From: PlanningSSD [redacted]
Sent: 24 October 2013 08:41
To: Thomas Callaway; Planning.Responses
Cc: Paul Cann
Subject: RE: Planning Consultation on EG/53/13/DOC

APPLICATION EG/53/13/DOC

Site Address: Former Brooks Nursery Eastergate PO22 0ED

Description of Works: Application for approval of details reserved by conditions 3, 5, 7, 8, 9, 10, 13, 15, 16, 17, 25, and 28, following a grant of planning permission EG/29/13.

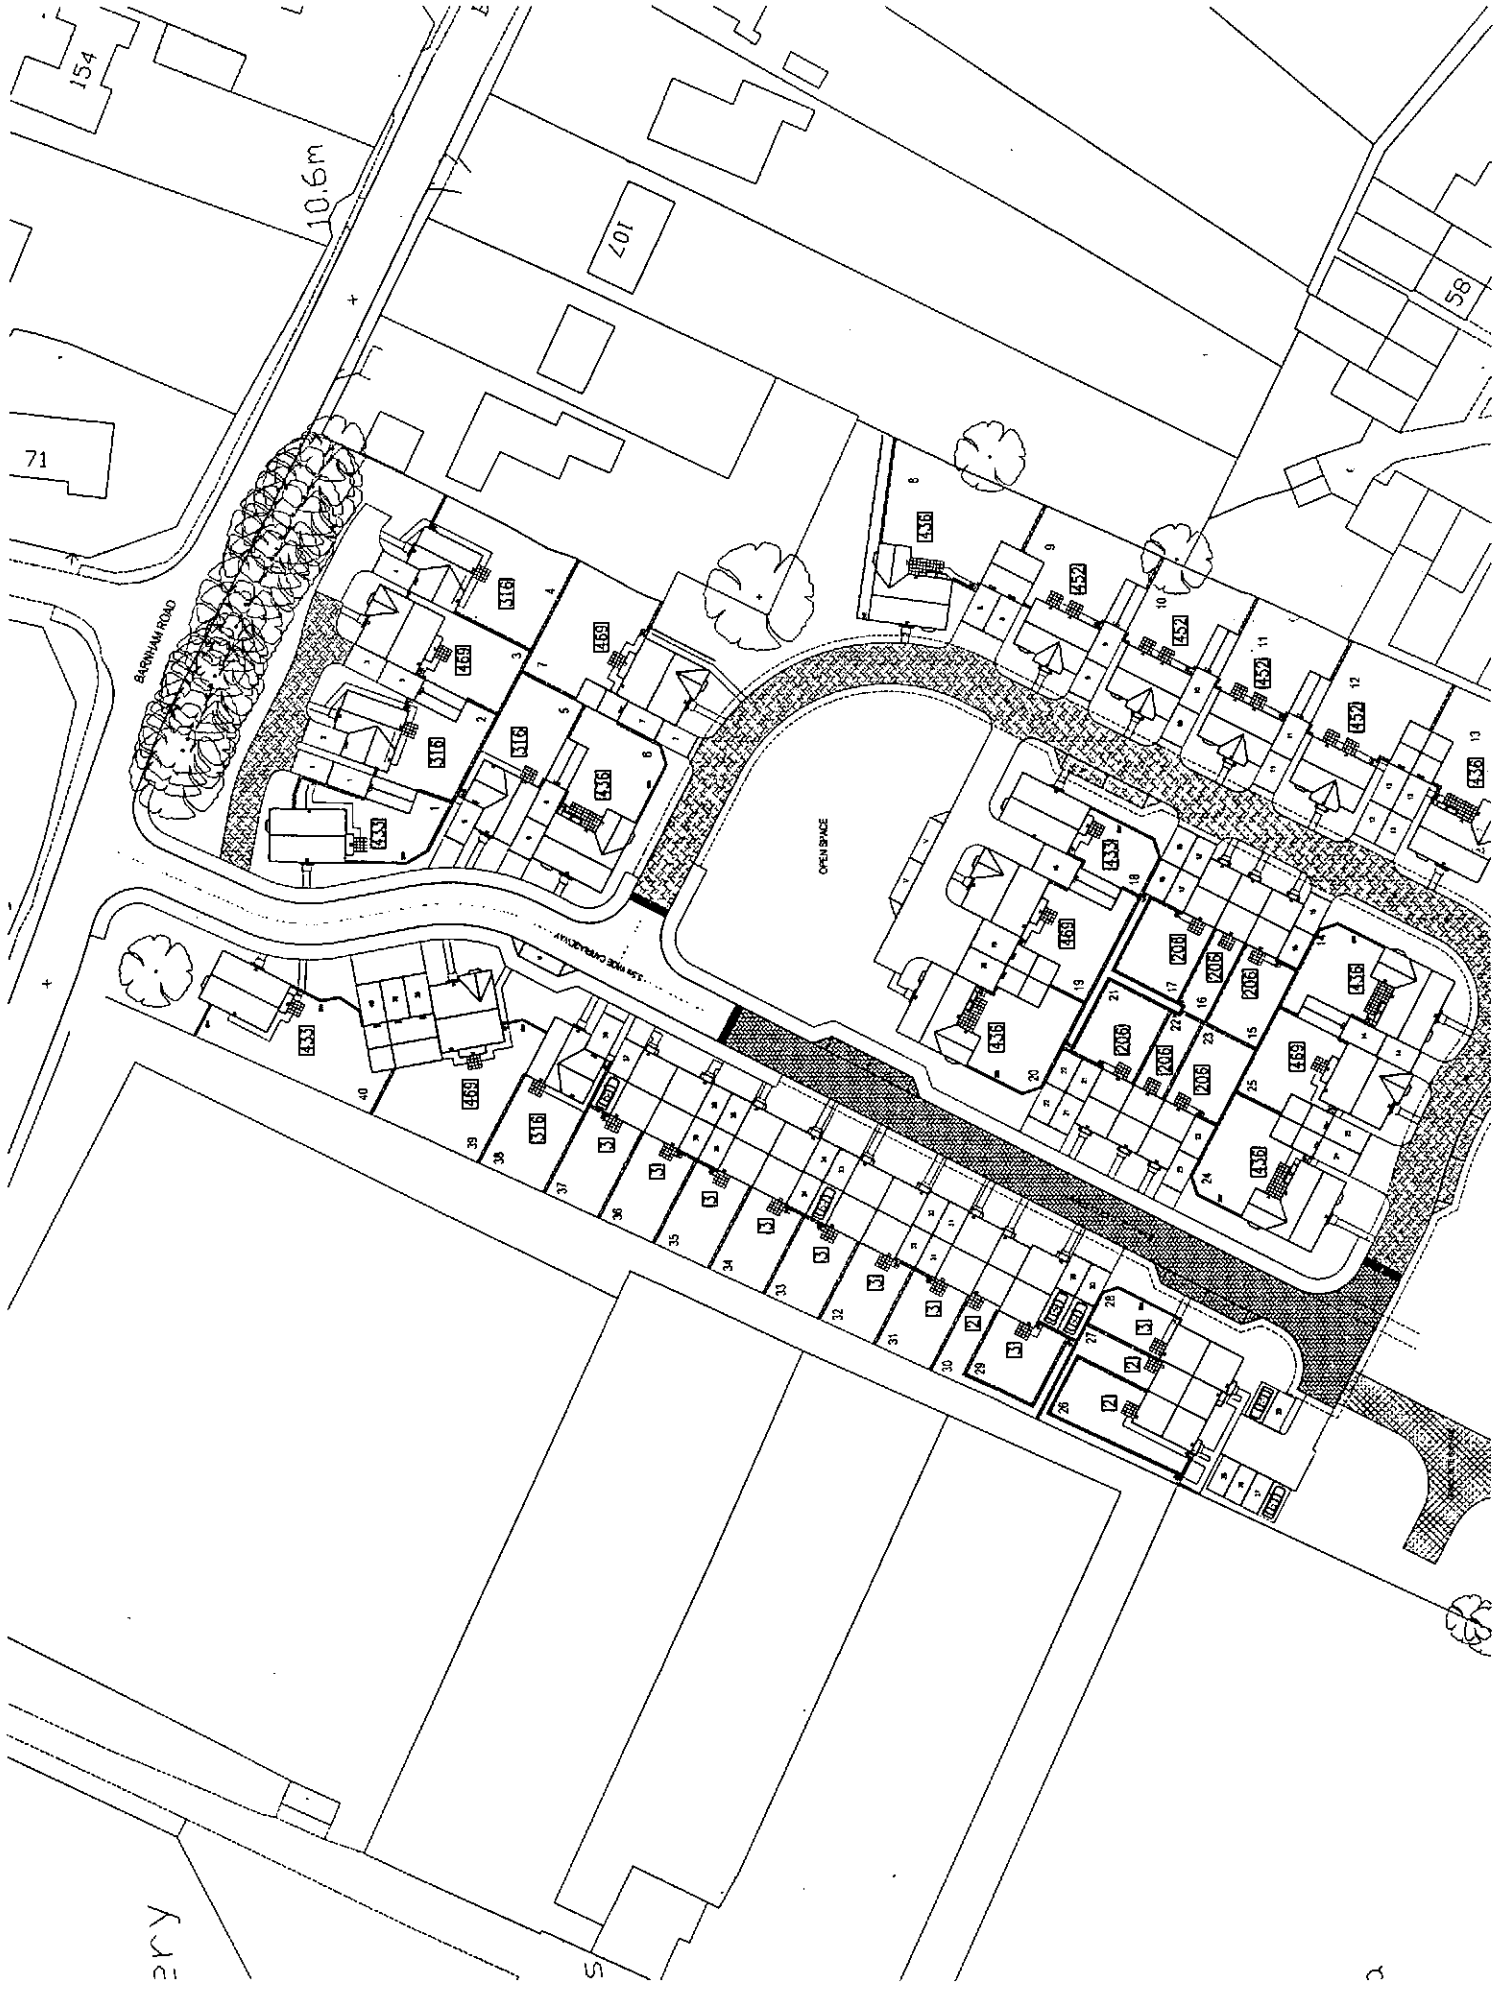
The surface water drainage strategy does not consider the use of infiltration structures, and no extended winter groundwater monitoring or winter percolation testing results have been submitted. Six months of monitoring (October to March) are required before a drainage strategy can be agreed. Infiltration must first be investigated before a discharge to the watercourse can be considered.

Until such time that the drainage strategy has been agreed, it will not be possible to agree any discharge of surface water to the ditch system. As discussed above, it would be expected that all efforts to dispose of surface water through infiltration must be investigated first.

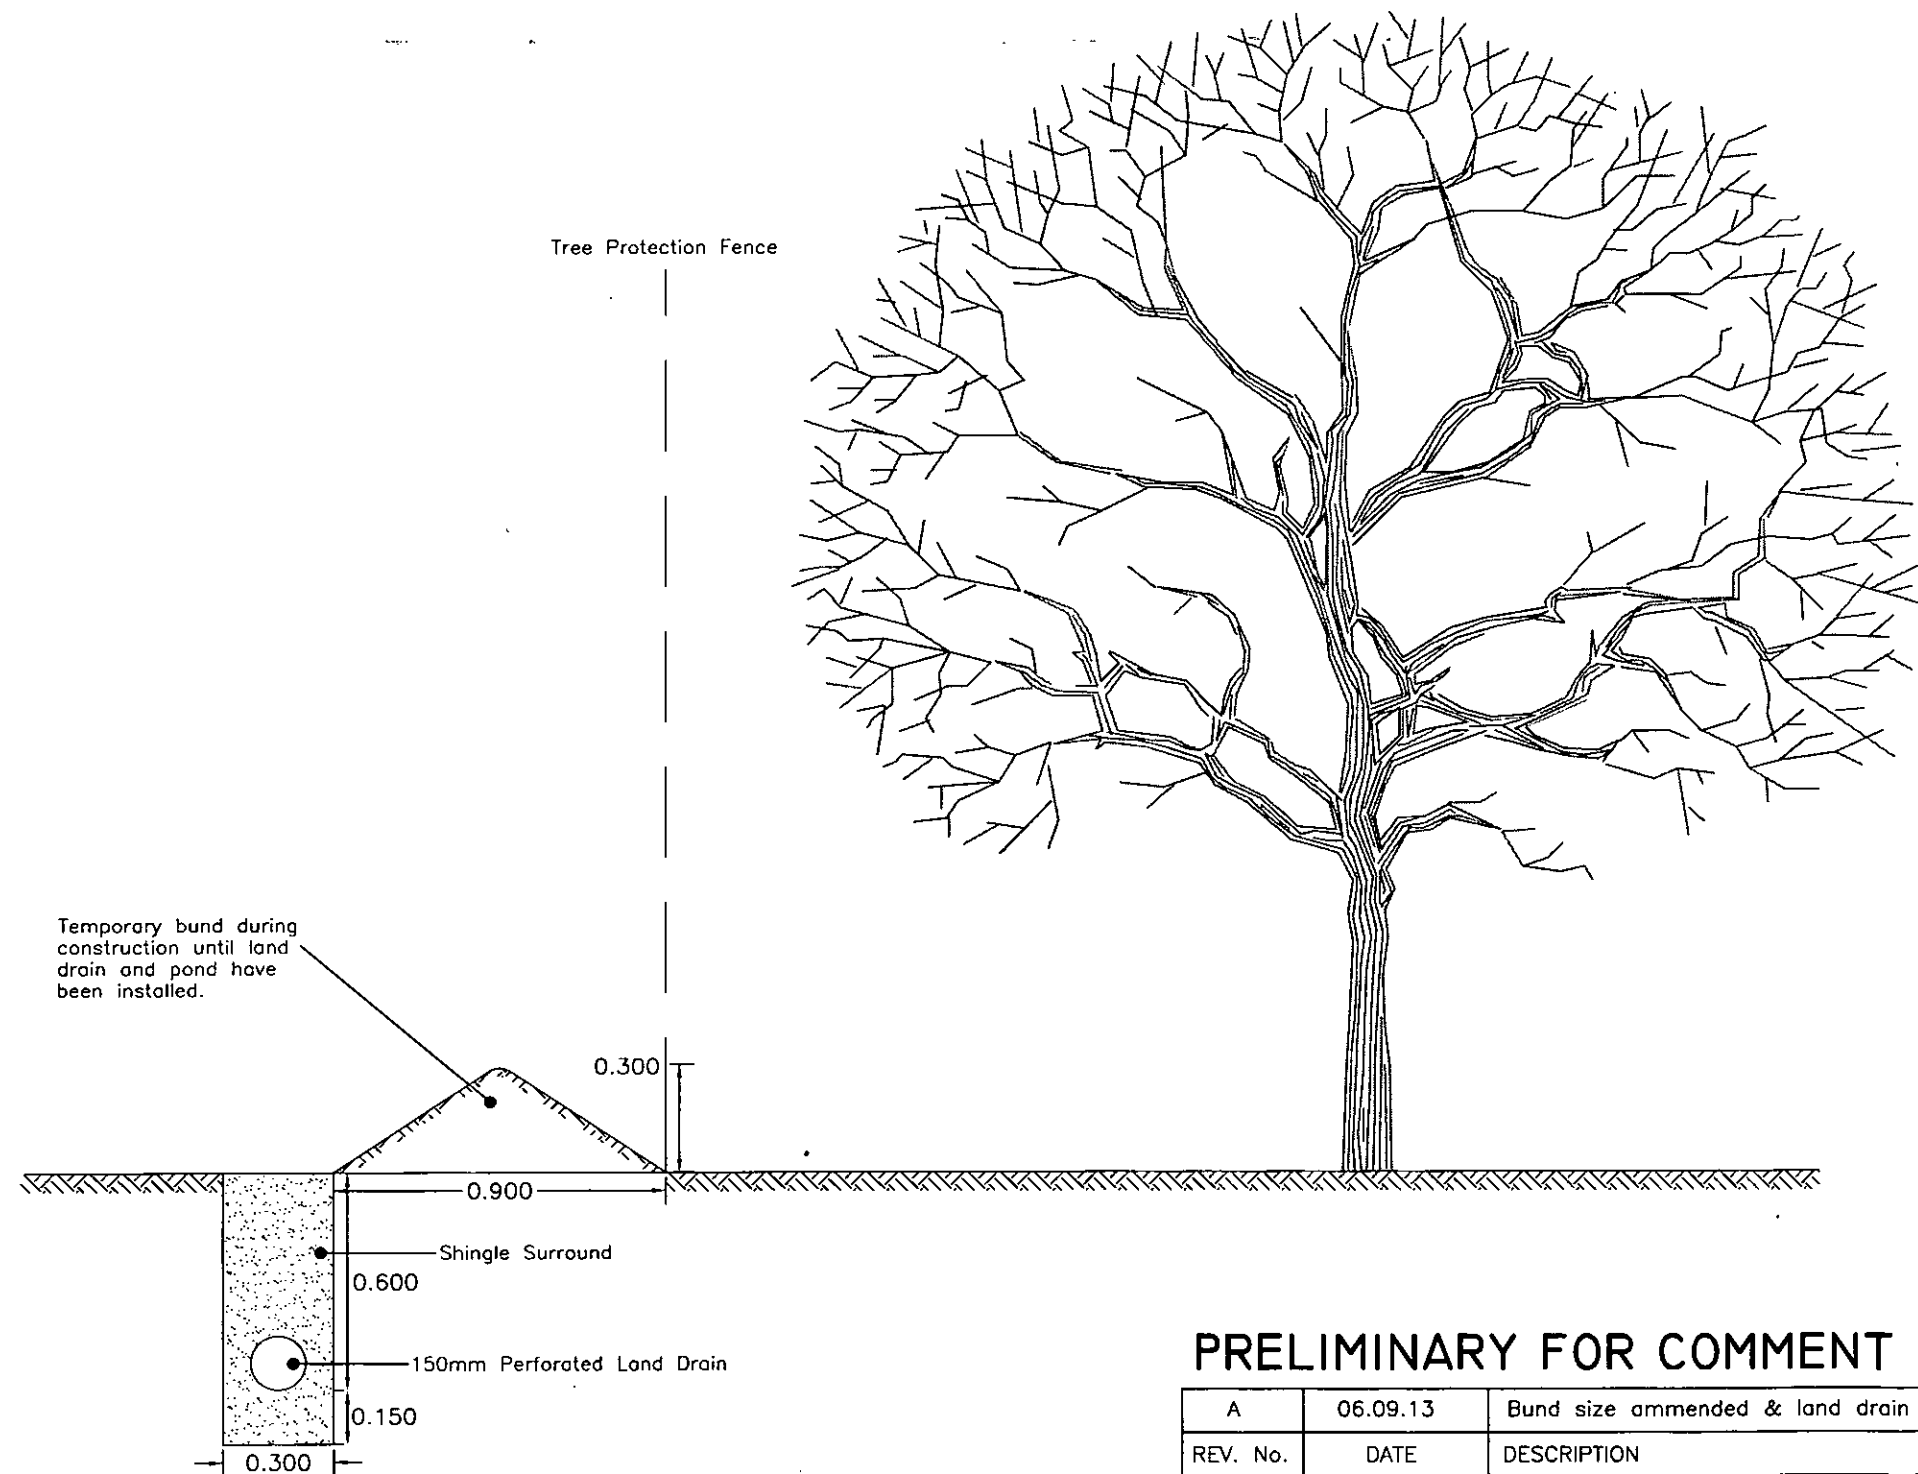
The proposed land drain on the eastern boundary should be contained within a geotextile wrapped 600mm wide trench, and the level of the pipe should be below the lowest ground level (if feasible) of the adjoining property to the east, which suffers groundwater flooding.
